**Marine
Management
Organisation**

4 October 2019

The Planning Act 2008 – Section 89 and The Infrastructure Planning (Examination Procedure) Rules 2010 – Rule 8 etc Application by Norfolk County Council for an Order Granting Development Consent for the Great Yarmouth Third River Crossing

Marine Management Organisation (MMO) response to Deadline 1

Figure 1. Distribution of all sampling stations at Great Yarmouth

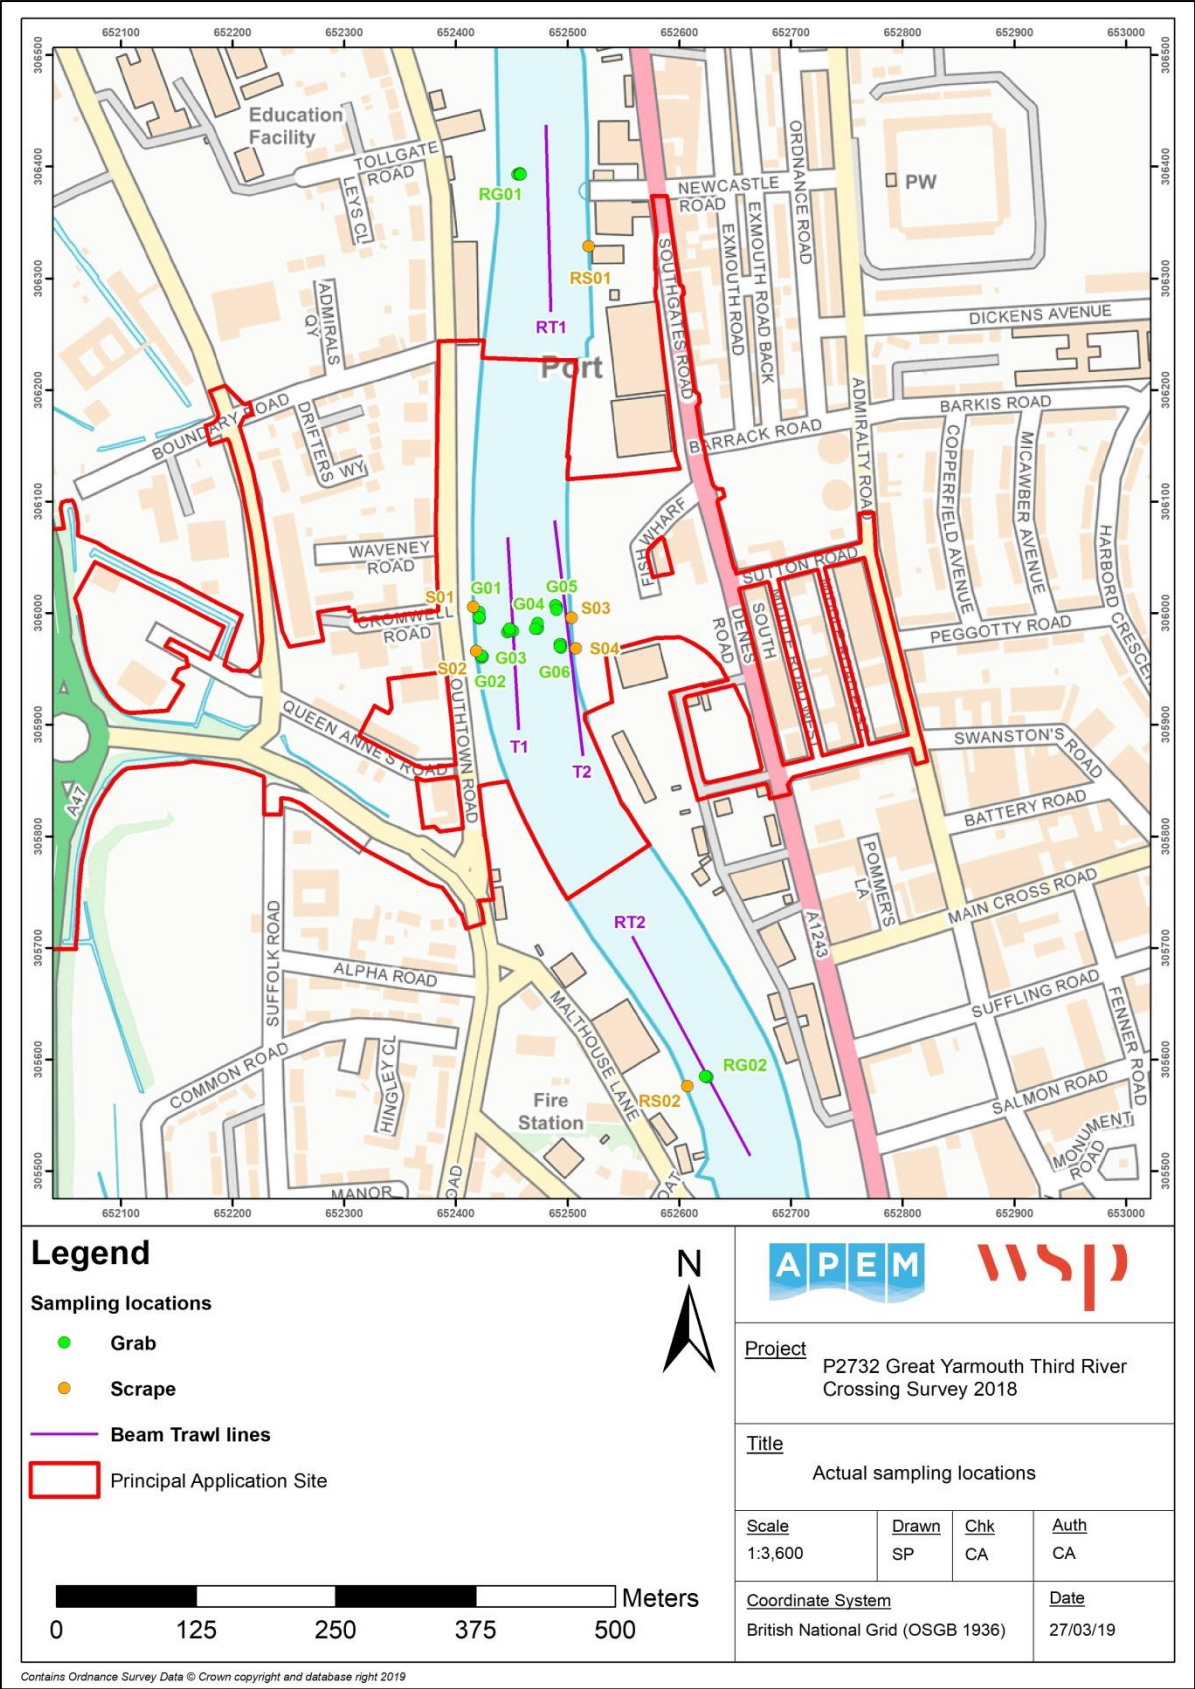
4.6.6. In Table 8.2 of the ES, the scoping opinion is given (ID7) which recommended that the ES should include an assessment of effects on benthic ecology and fish, including migratory fish, in particular, those that migrate through the River Yare. The ES must assess any likely significant effects on protected fish species and species of conservation concern, including European eel, smelt and river lamprey, and present an assessment of potential impacts of noise and vibration on sensitive aquatic receptors, including benthic ecology and fish receptors. The applicant has not provided an assessment of the impact on migratory species present or the potential impacts on these species.

4.6.7. The applicant has referenced the scoping opinion in paragraph 8.9.1 that a limitation of the 2m beam trawl is that it would underrepresent bigger fish and migratory species as this type of gear does not adequately target these fish.

However, in paragraph 8.8.49 this is not taken into consideration as the applicant states that “no protected or noted species (such as migratory fish) were recorded in the (benthic ecology) and fish surveys” so no further assessment was made to assess the impact on these species. The applicant must utilise other sources of previous surveys and background information to provide a desk-based assessment of fish species present in the area in addition to the snapshot provided by the four trawl surveys.
